Our Ref: JH/I2087/jh

5 October, 2023

**RE: PROPOSED RESIDENTIAL AGED CARE FACILITY,
59-67 KARNE STREET, NARWEE**

2. This addendum traffic document has been prepared to support the response to submissions report for the Narwee Parklands Care Community State Significant Development Application (SSD-45024776) located at 59-67 Karne Street North, Narwee. The NSW Department of Planning and Environment (DPE) placed the Environmental Impact Statement and the accompanying technical documentation on public exhibition from 14 February 2023 until 13 March 2023. During the exhibition, a total of 23 submissions were received in response to the public exhibition of the EIS. These included submissions made by state and local government agencies as well as the general public.

7.3m AMBULANCE VEHICLE
SWEPT PATHS

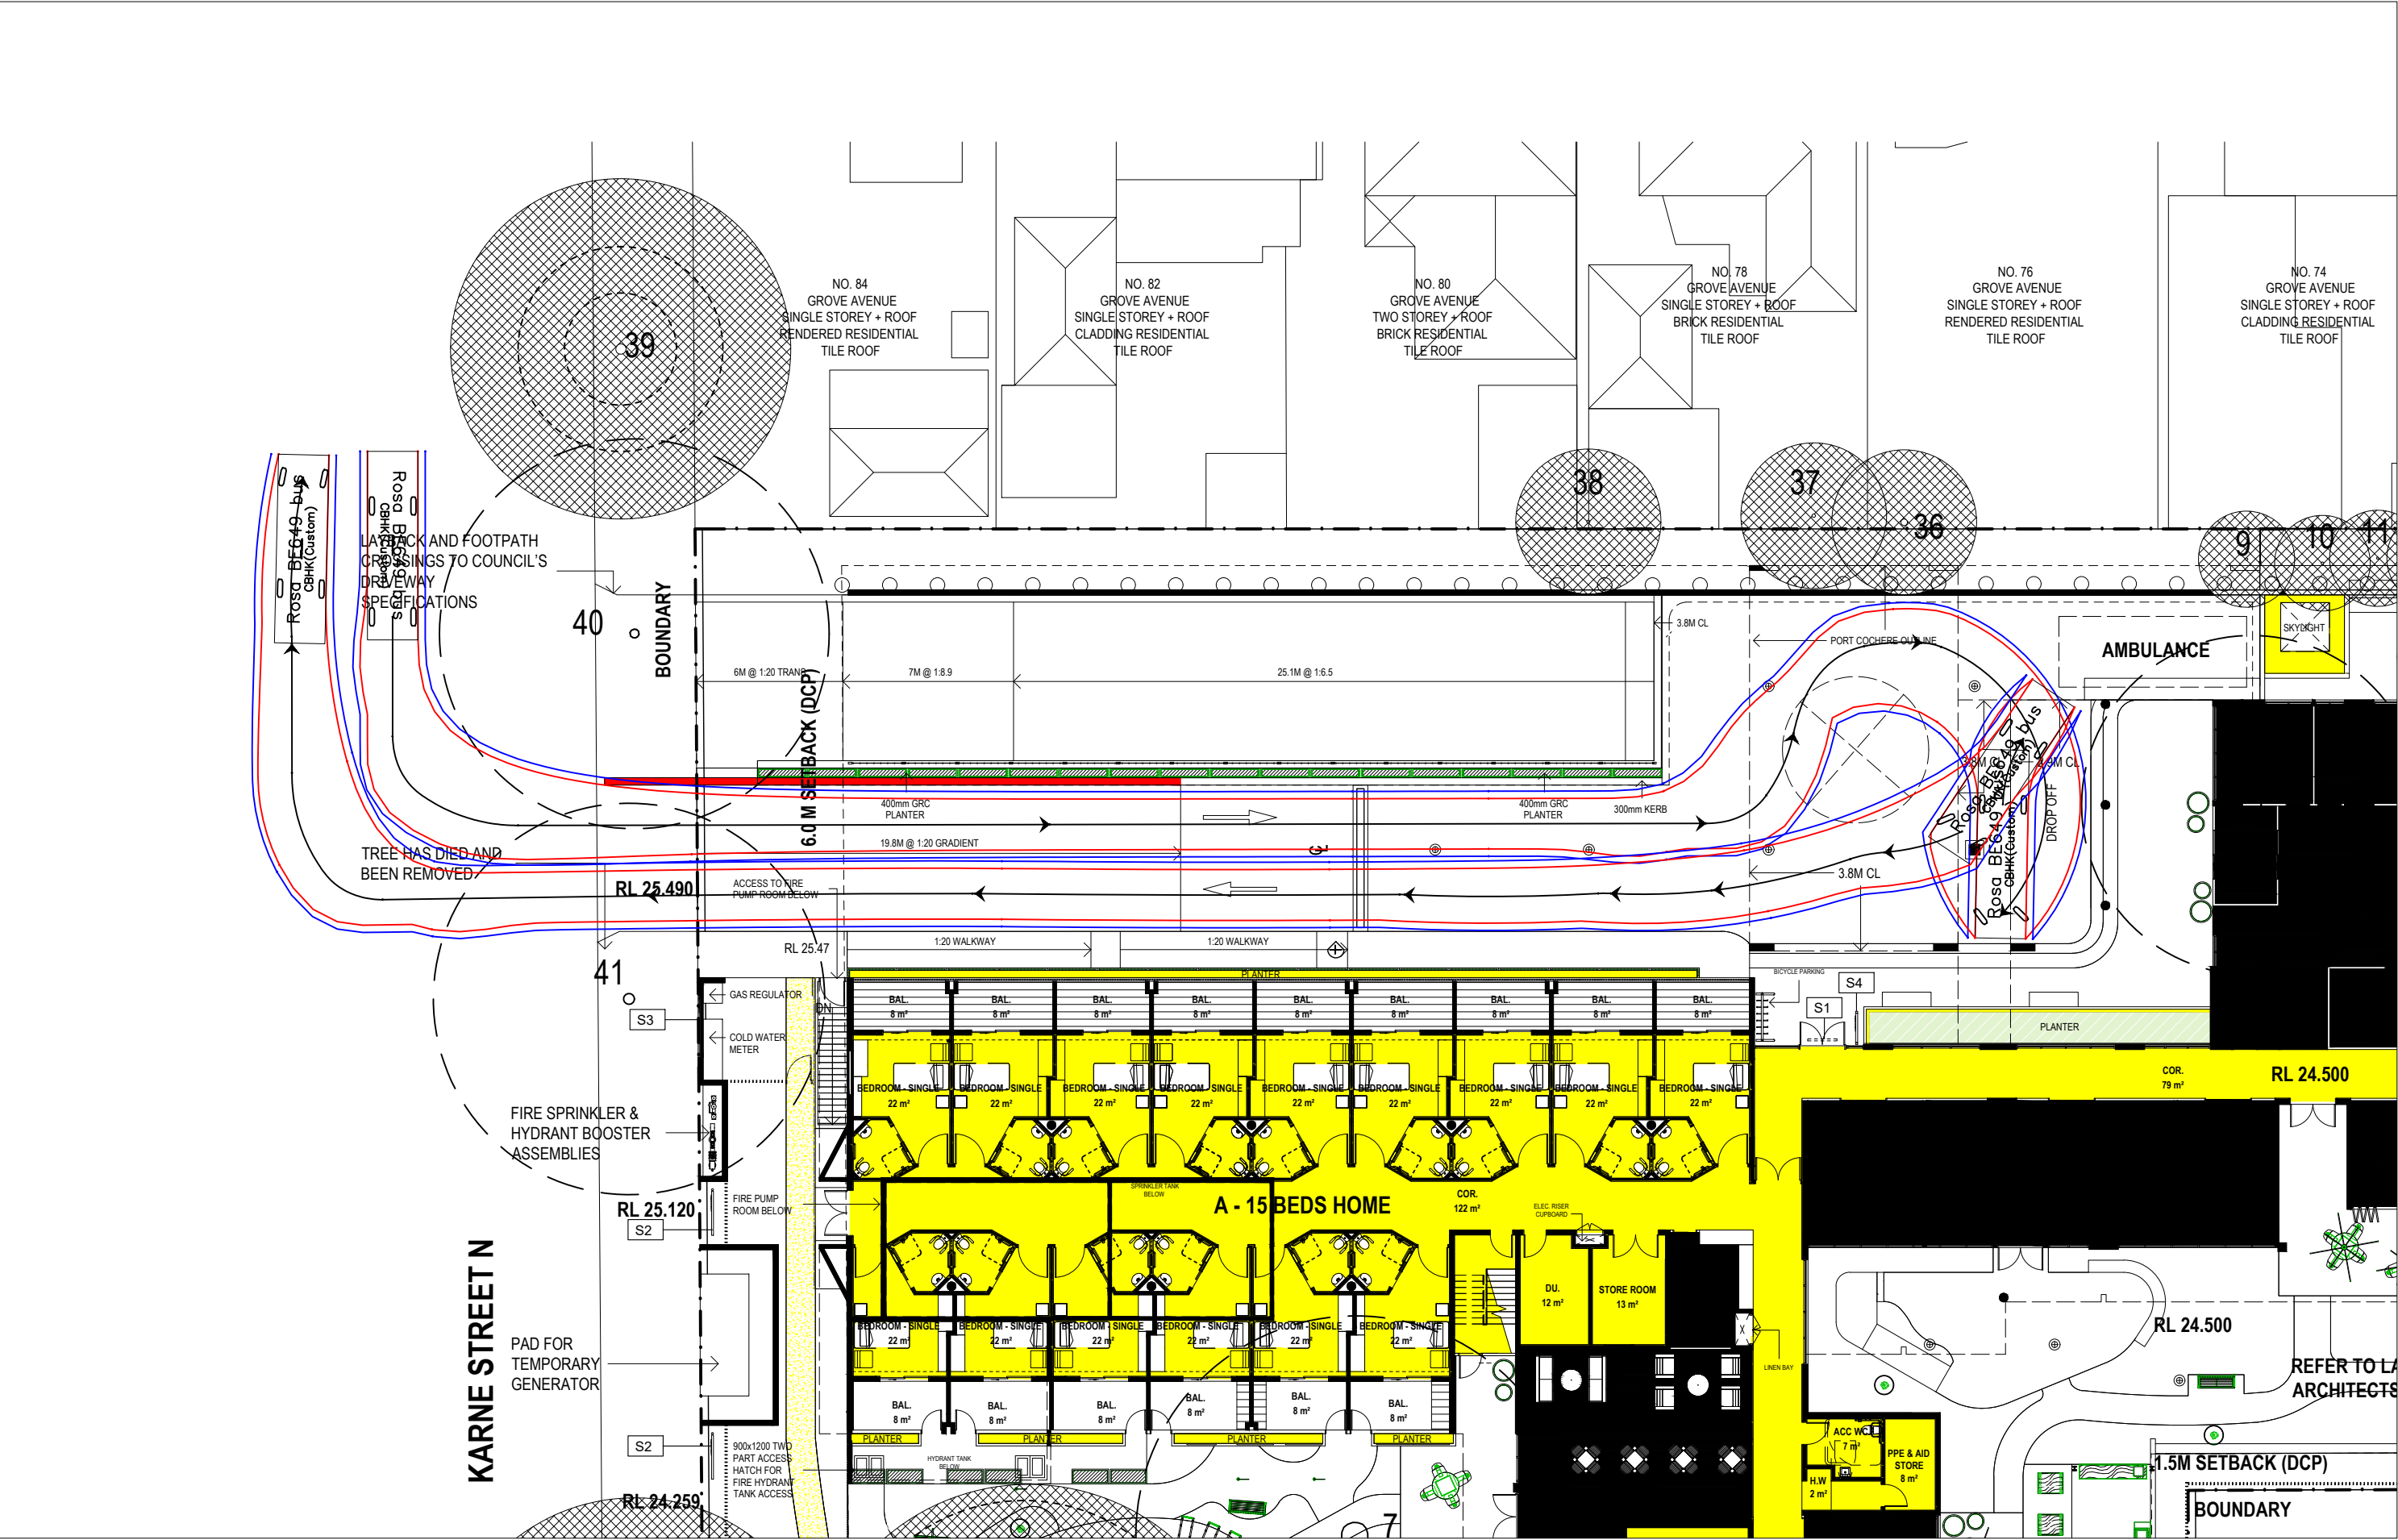
- (d) *Further consideration is to be given towards the ambulance turning circle in accordance with the relevant standards in Vehicle Access Specifications – NSW Ambulance, noting the sensitive use and increased potential for ambulance attendance to the site.*

11. The ambulance swept paths in our previous report (Figure A3) are for a 7.3 metre long ambulance, the longest vehicle used by NSW Ambulance.
 - (e) *The architectural plans must be amended to accurately identify the parking spaces breakdown including allocating for visitors and staff.*
